From: Chantelle Bashford <Chantelle.Bashford@arun.gov.uk>
Sent: 13 March 2020 10:23
To: Planning.Responses <Planning.Responses@arun.gov.uk>
Subject: RE: Planning Consultation on: BR/31/20/PL

Please see comments below from Private Sector Housing.

APPLICATION NO: BR/31/20/PL

Description of Works: Part change of use of ground floor & formation of a first floor rear extension to create 2 No. self-contained studio flats with associated refuse/ recycling & cycle store (re-submission following BR/233/19/PL)

**GROUND FLOOR
PROPOSED FLOOR PLANS**
Scale 1:50

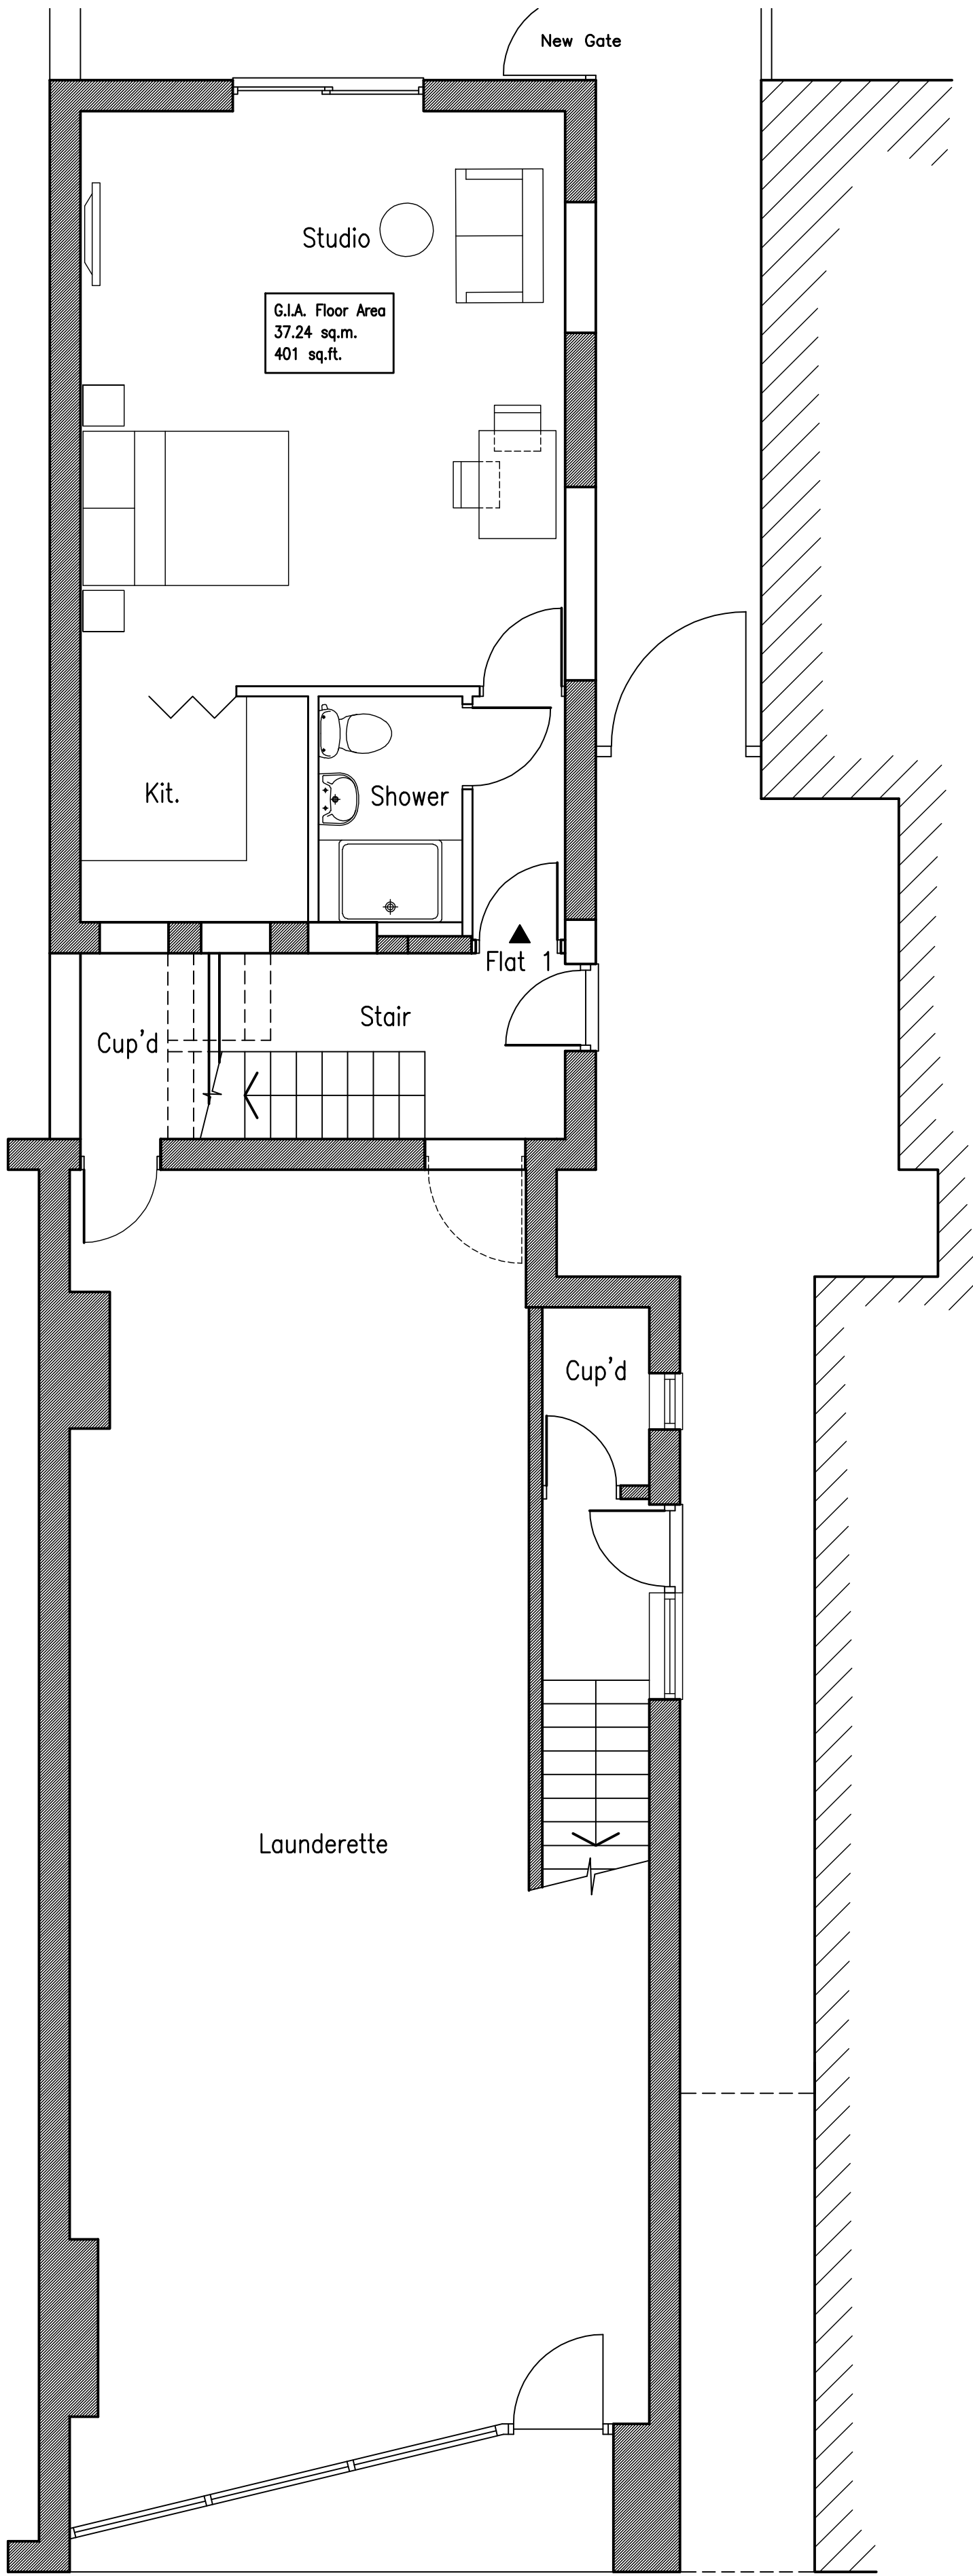
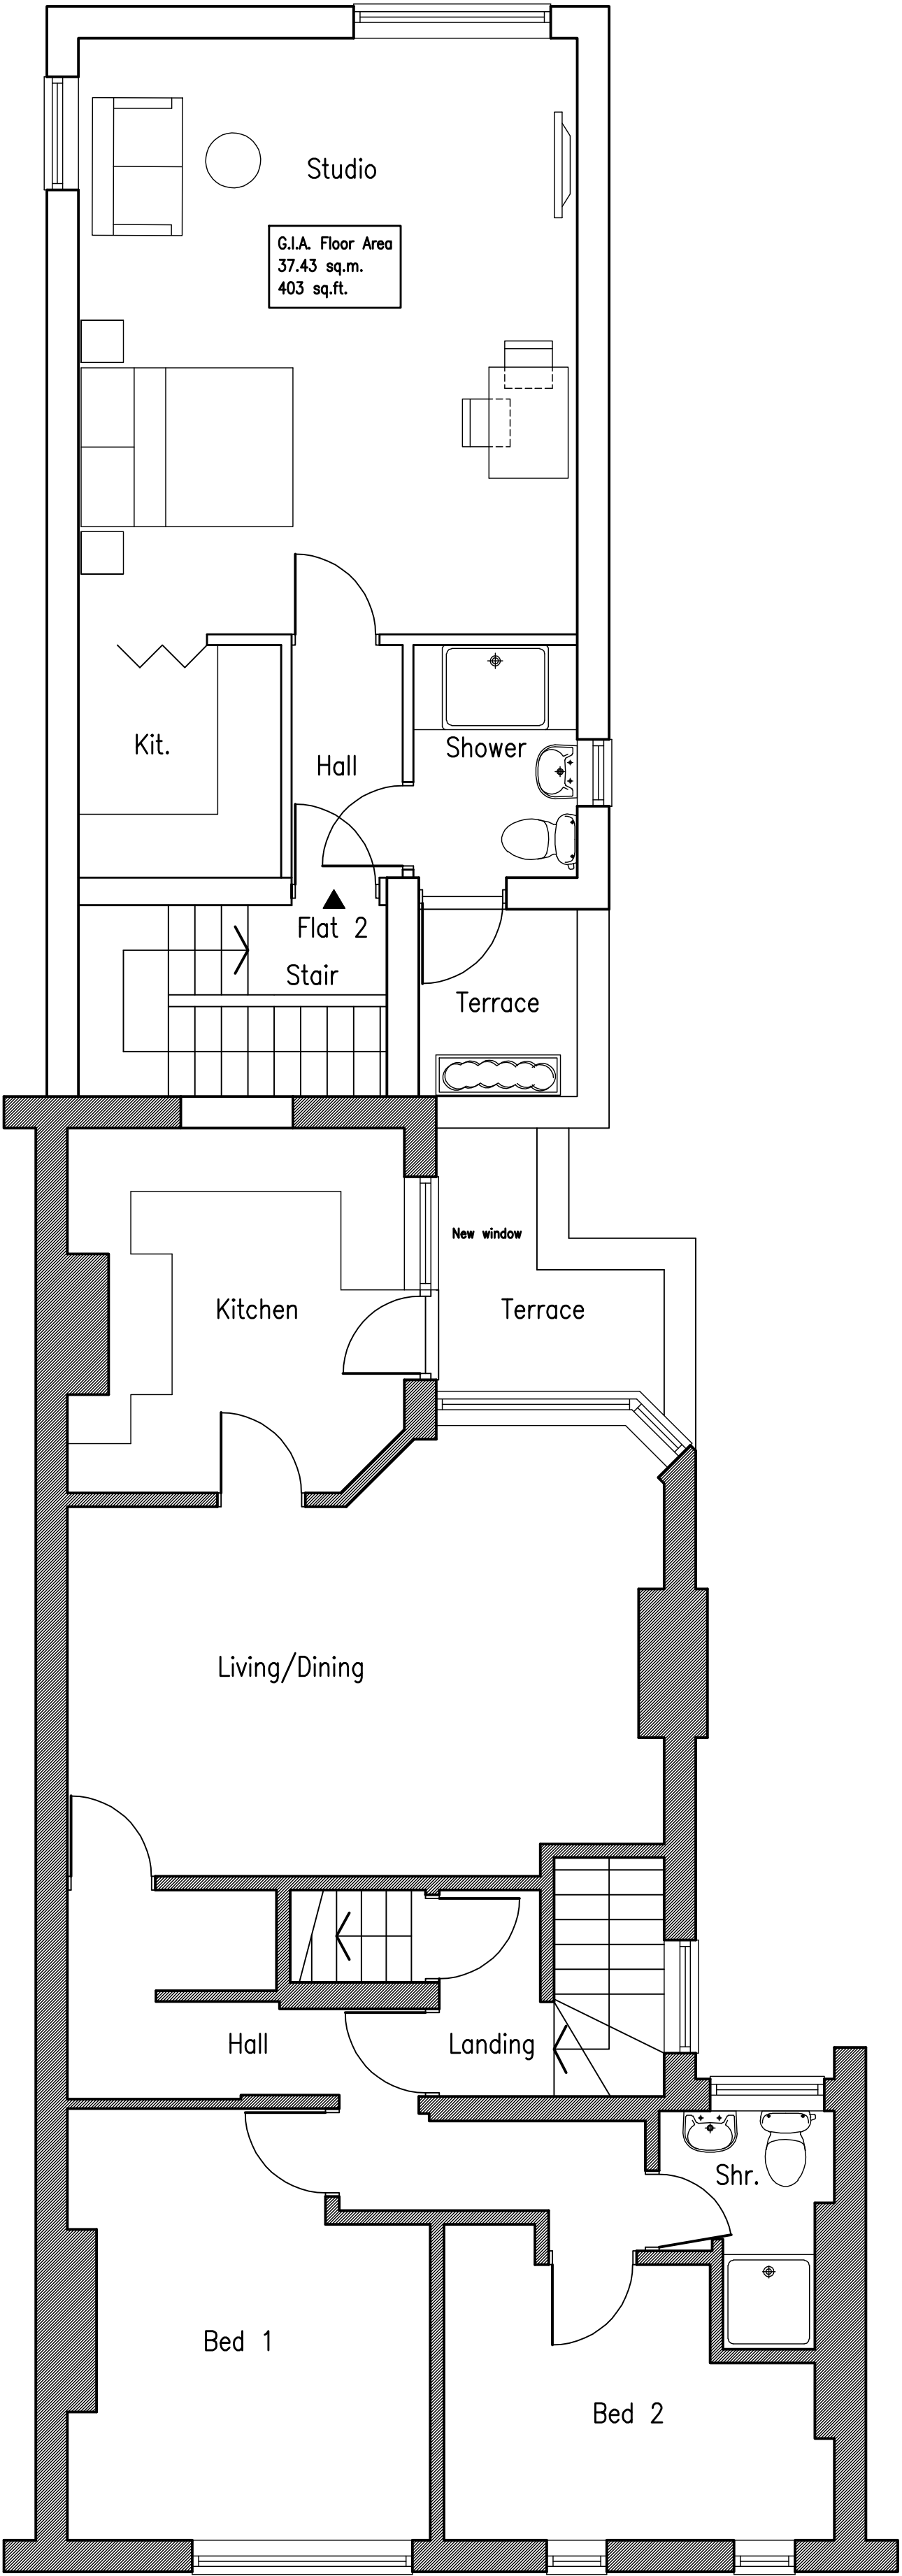
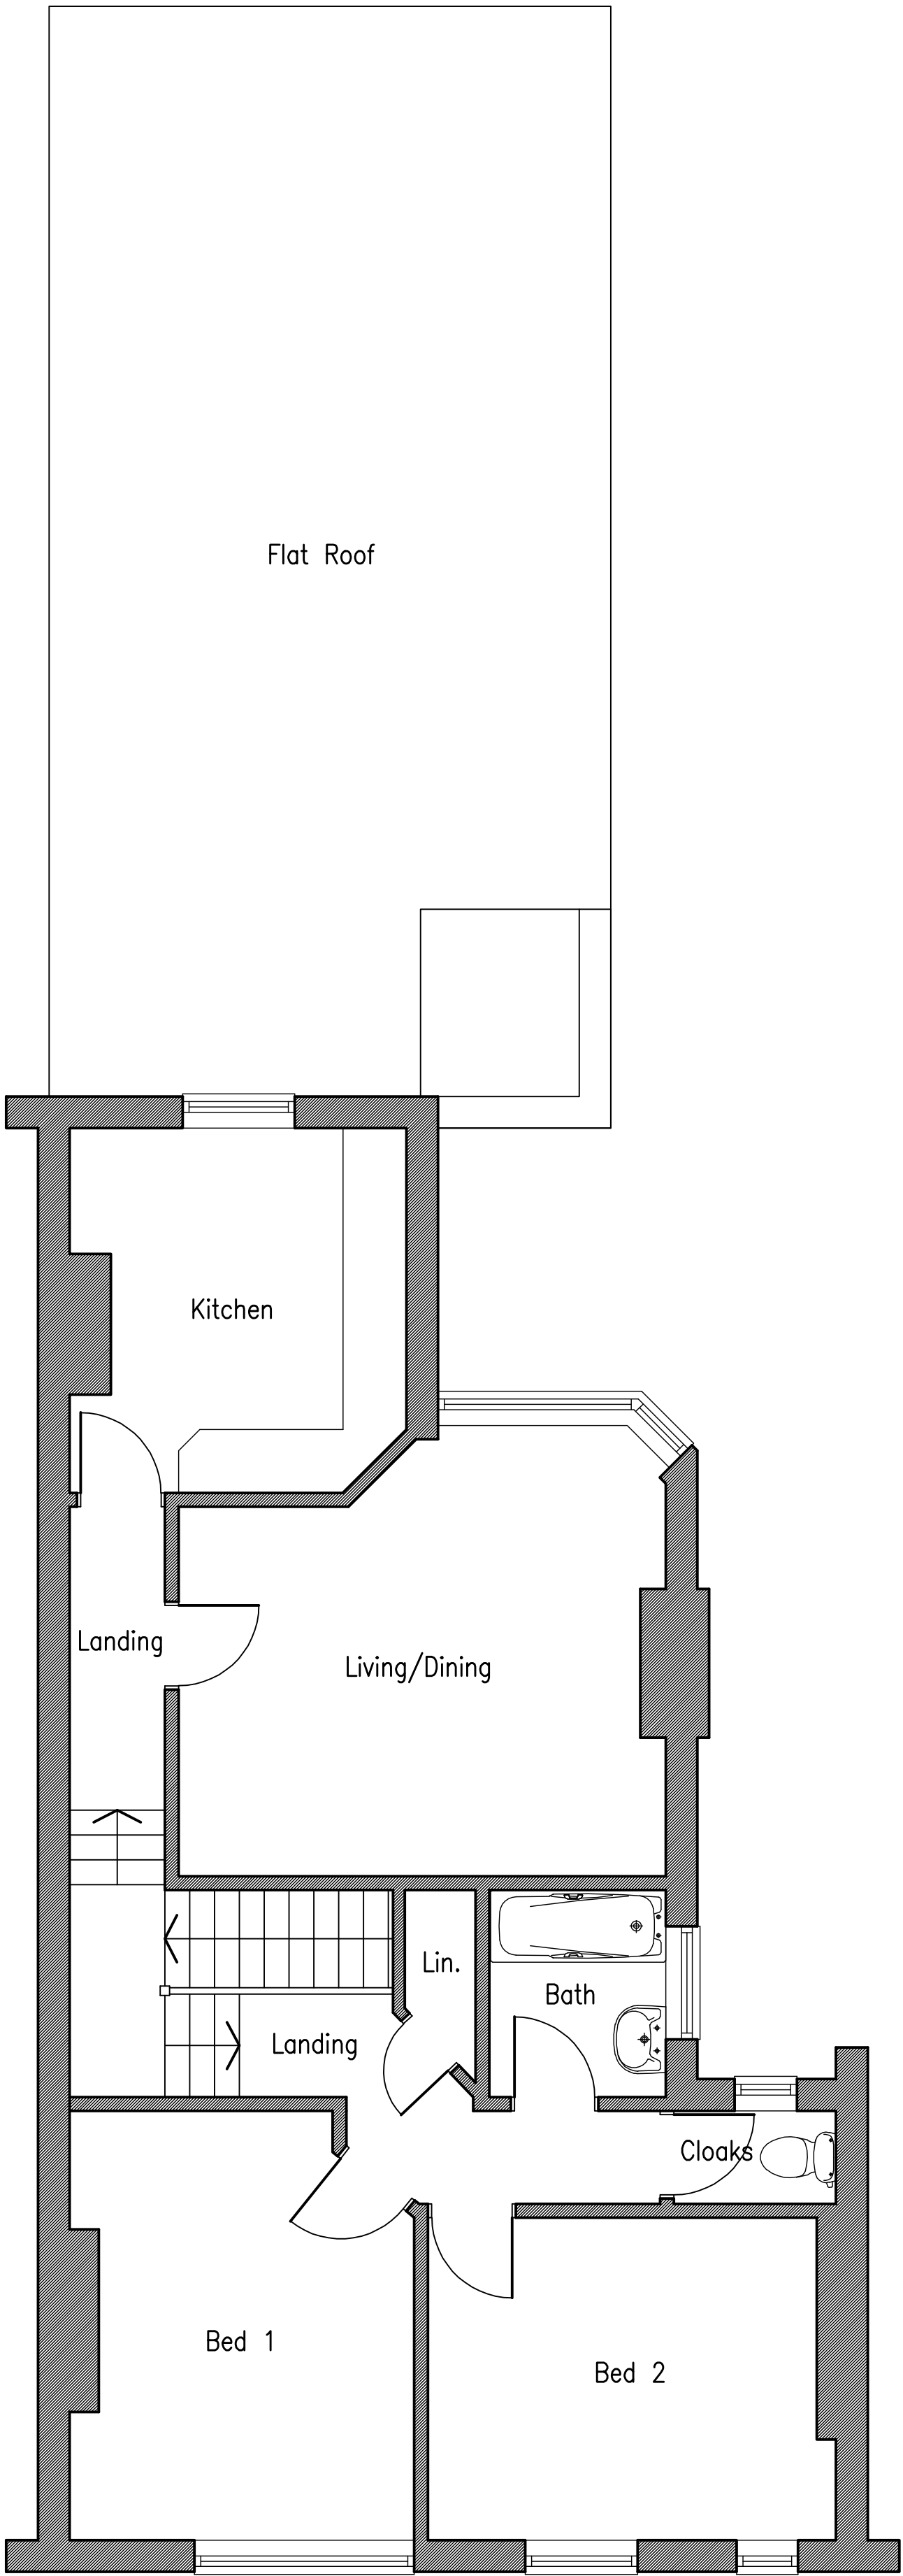
- There should be adequate fire separation between the commercial unit and the communal staircase serving the new self-contained flats
- The rear under stairs cupboard accessed via the laundrette should afford 30 minutes fire resistance. If there is a source of ignition present within this cupboard then interlinked detection should be fitted within the cupboard too

- A mixed Grade A, LD2 and Grade D1, LD3 fire system should be maintained and installed. Grade A, LD2 fire system should already be installed as the existing building is across three storeys.
Grade A, LD2 system:

- Interlinked detection throughout the escape routes
 - Interlinked heat detection to the laundrette
 - Interlinked heat detection to each self-contained flatGrade D1, LD3 system:

- Non-interlinked mains-wired smoke alarms with integral battery back-up to each self-contained flat
- 30 minute fire resisting escape route, which would include providing a 30 minute fire resisting and self-closing fire door to each self-contained flat

- Any bathrooms and kitchens without windows for natural ventilation should have adequate mechanical ventilation
